Recommendation Report for Planning Permission for Works or Extension to a Dwelling

REF NO: **AW/37/14/**

LOCATION: 18 Fish Lane
Aldwick

PROPOSAL: Two storey & chalet extension with dormer to front & rear single storey extension. Resubmission of AW/298/13

sheet 1 of 4

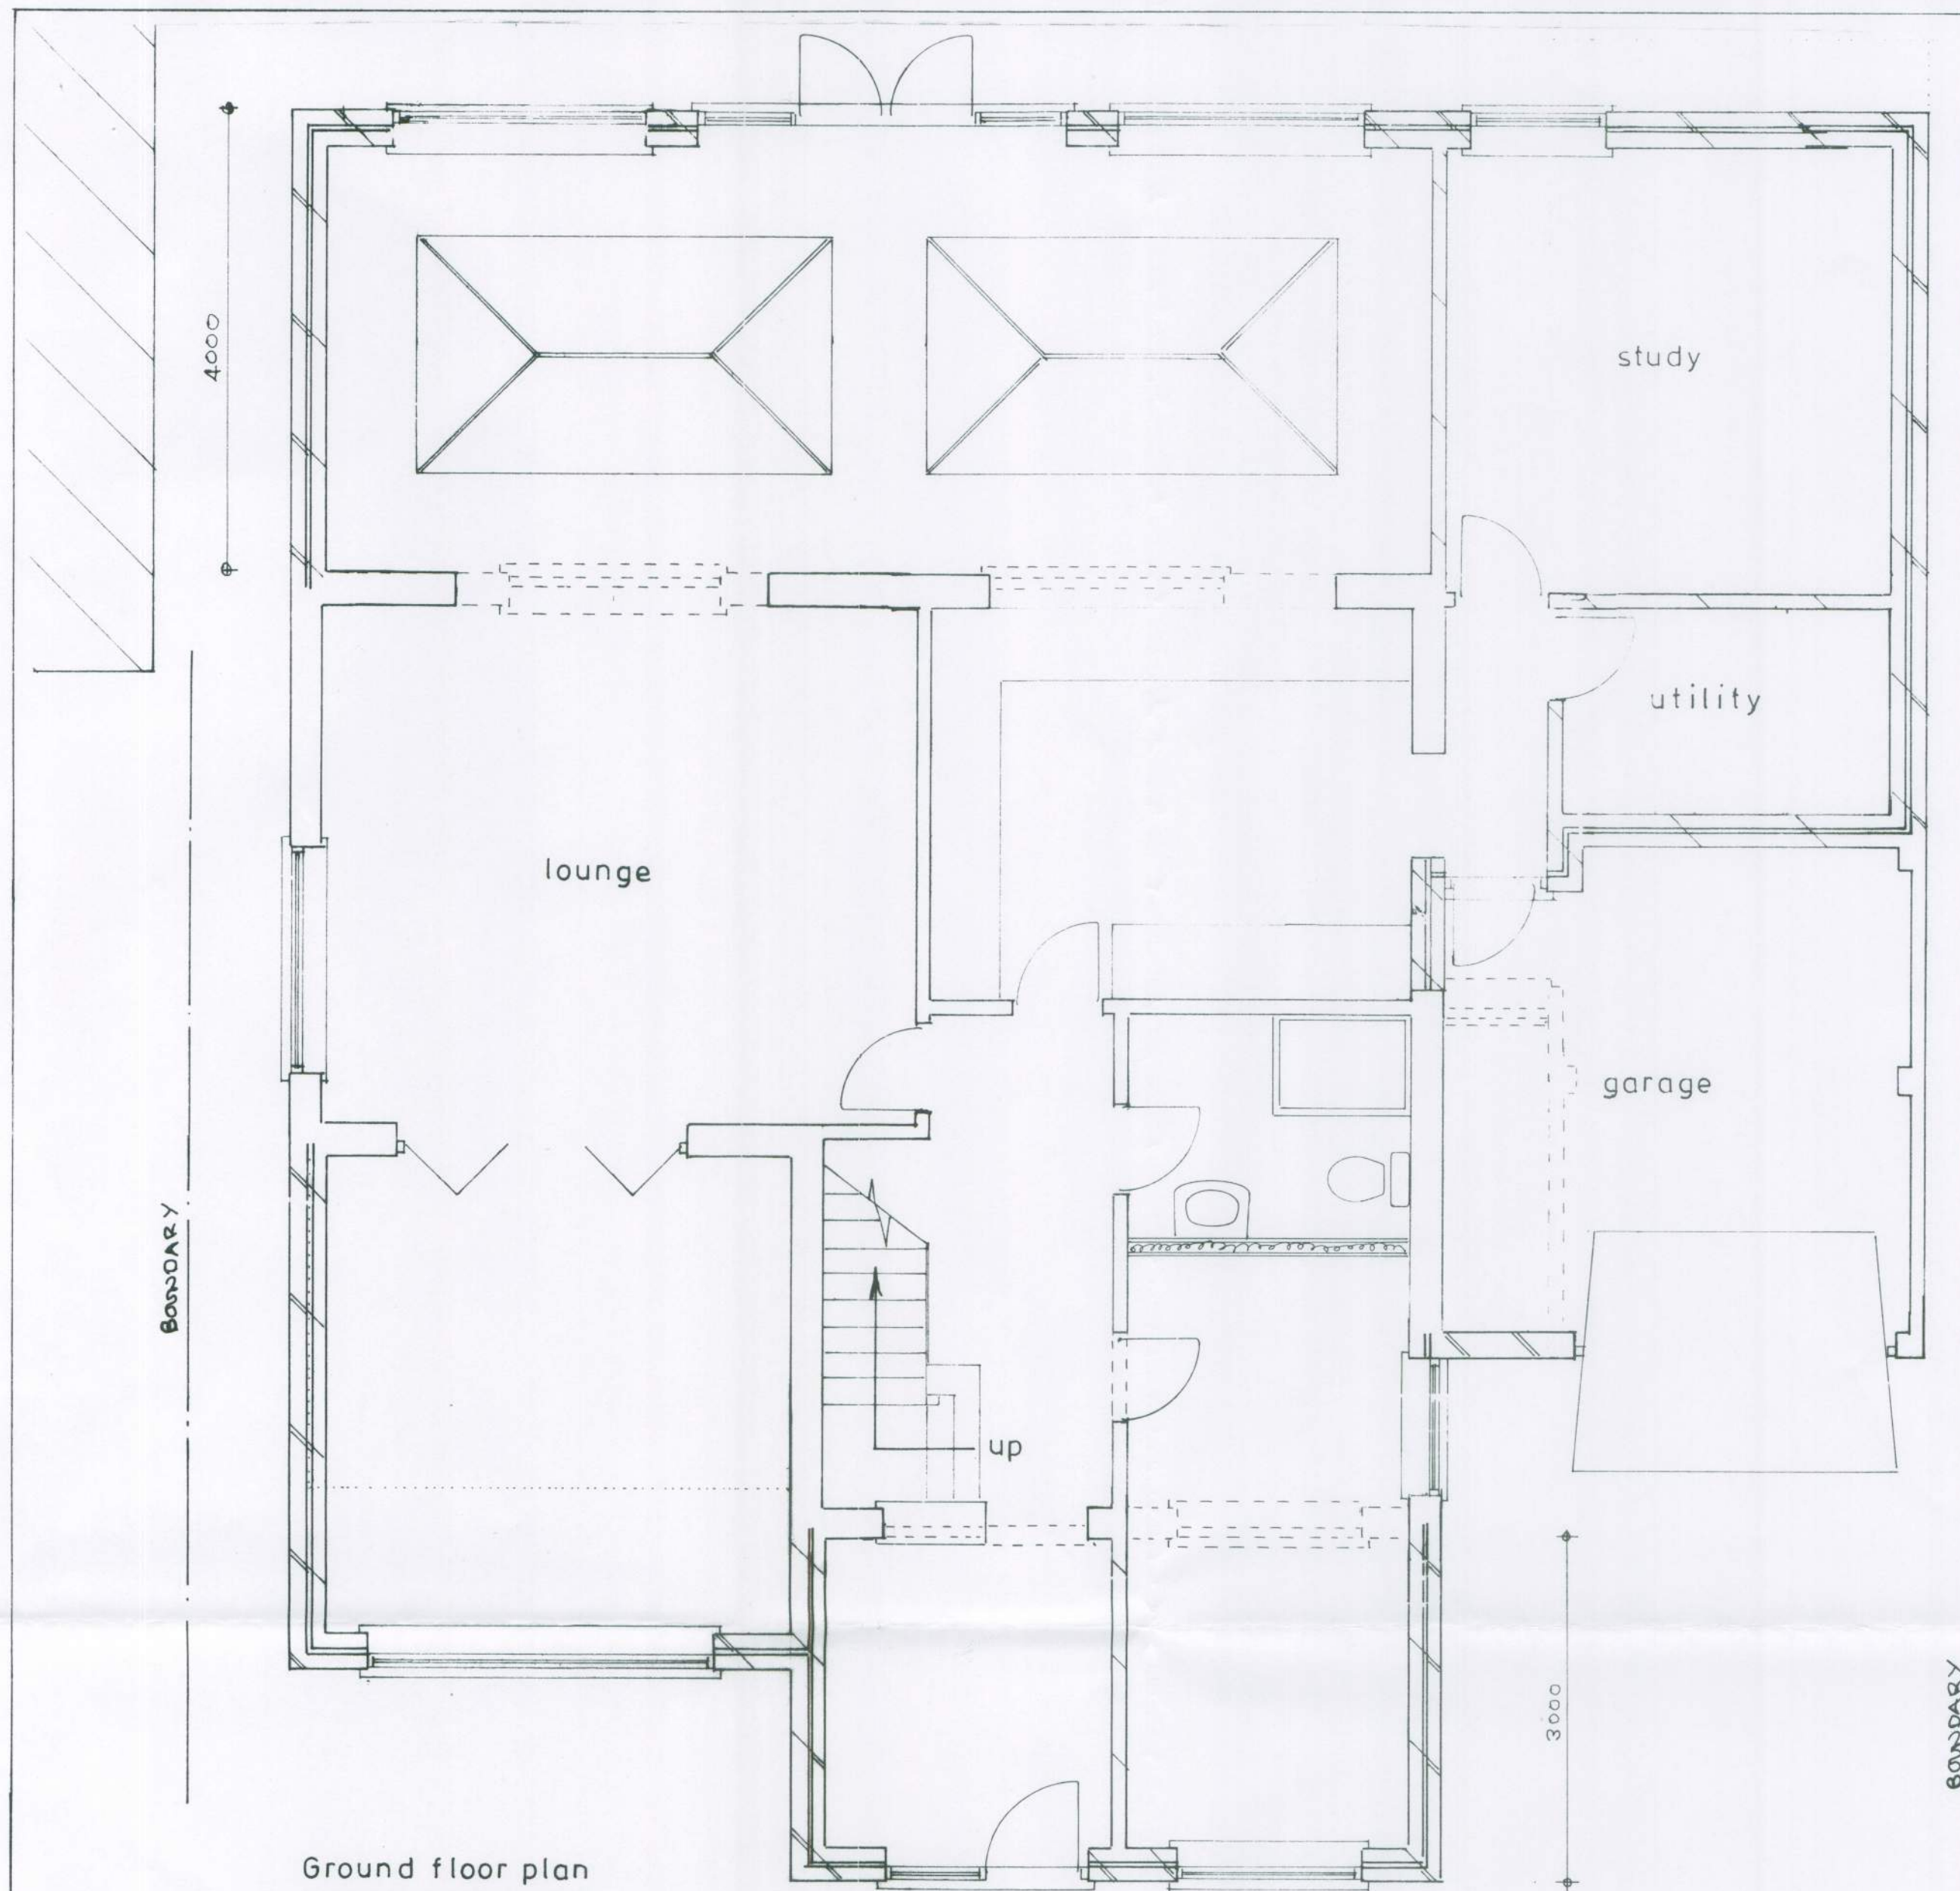
Members strongly objected to the application on the grounds that the planned extension does not relate sympathetically to and is not visually integrated with, the existing building in siting, design, form, scale and materials; that the extension comes too close to the side boundary and is unneighbourly and overbearing and that the extension compromises the established spatial character and pattern of the street. Therefore, Members agreed that the application is in direct conflict with Policy DEV19 of the Arun District Local Plan 2003. The application also conflicts with the Development criteria of Aldwick Parish Council's Parish Design Statement.

Development is no improvement on the previous scheme. To the west is a two storey building which has been constructed extremely close to the boundary and the proposed development would sandwich my property between the two massive developments. Front extension is well in front of current building lines. Development is not in keeping with the original features of the traditional Fish Lane concept, dominant to a neighbours presence and generally without consideration to others. Detrimental to property values.

The proposed two storey extension on the western side will be no greater than the existing width of the dwelling and will still retain a gap of 0.9m from the boundary. In view of its front projection it will be sited approximately 4m from the neighbouring property to the west No 20.

The plans now submitted comprise two extensions to the front which has reduced the overall height of the two storey element adjacent to the western side boundary. The property has a conservatory on the front western side and this is to be removed and the two storey extension with front dormer will be set back from the front flank wall of the dwelling leaving a visual break between the adjacent property No 20. The adjacent two storey element will be sited in the middle of the dwelling and will be no higher than the existing roof height with a front projection of 3m with gable feature that will replicate the style of the existing gable. There is a garage on the eastern side with store and the single storey side extension which is sited approximately 0.375m from the eastern side boundary will link up with the rear extension having a rear projection of 4m.
